From: Contact Centre (CRM) <contact@ribblevalley.gov.uk>
Sent: 27 November 2025 07:41
To: Planning
Subject: Planning Application Comments - 3/2025/0878 FS-Case-768946609

Planning Application Reference No.: 3/2025/0878

Address of Development: Honfleur, 3 Grindleton View, Chatburn, BB7 4BE

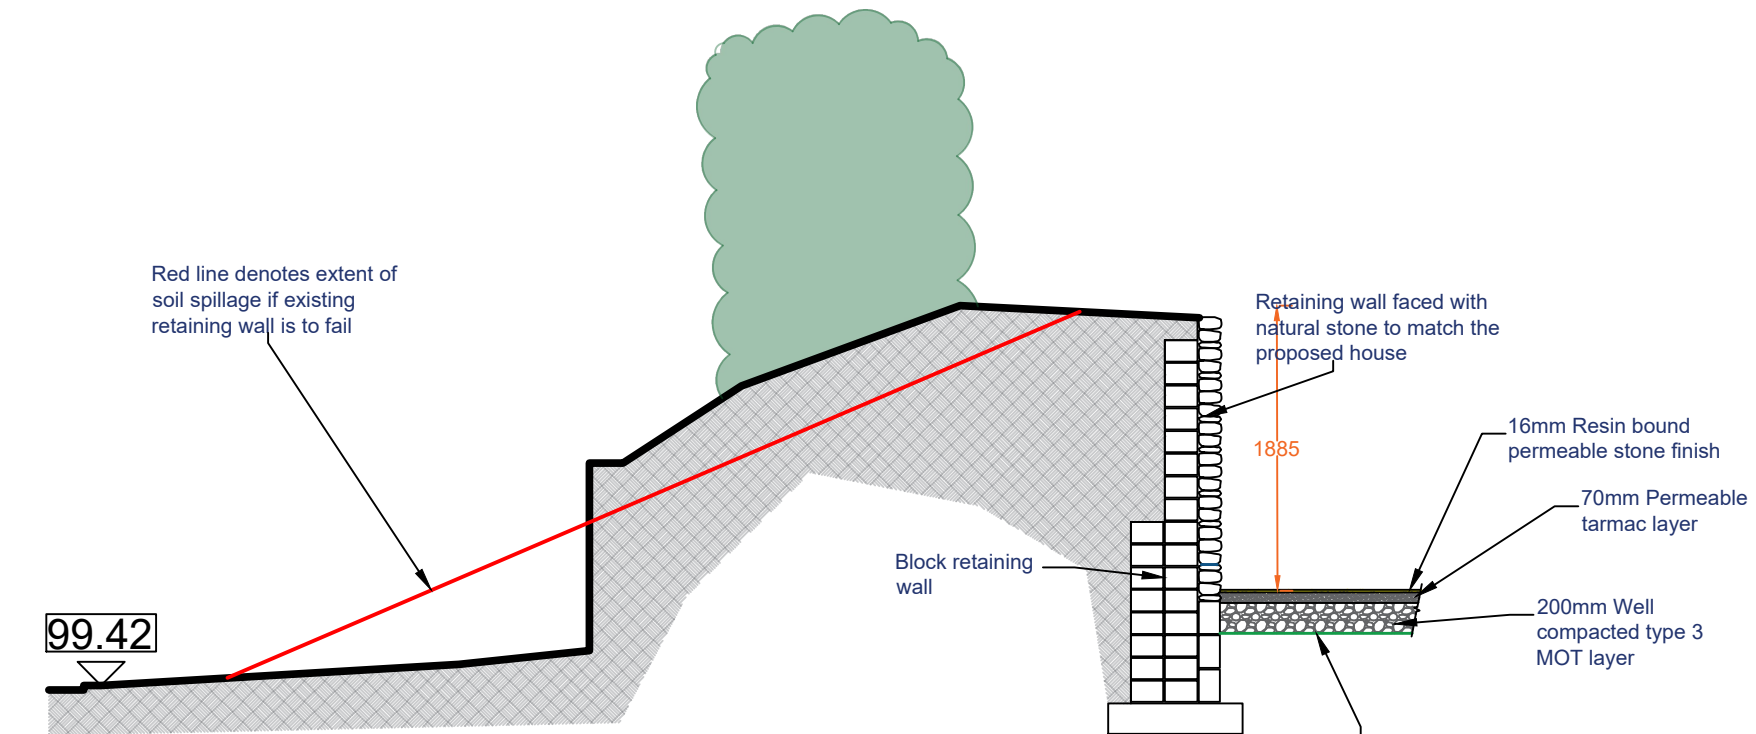
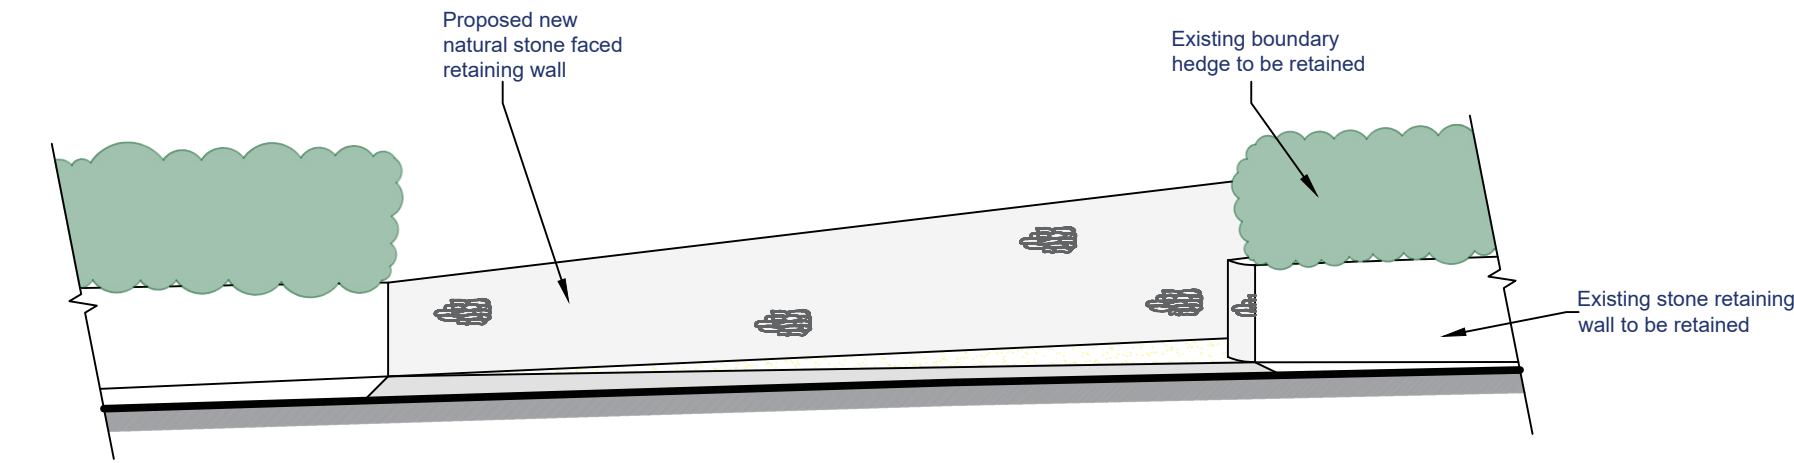
Comments: We have no objection to the application as a whole, as it appears to make more efficient use of the land at a time of housing need, without representing overdevelopment. Our one query is why a separate access is proposed onto Sawley Road, rather than using Grindleton View. Given that many drivers are speeding well in excess of the 30 mile per hour limit when entering or leaving the village, and that enforcement of speed limits appears in this area to be more or less non existent, the proposed access surely heightens the risk of a serious accident.
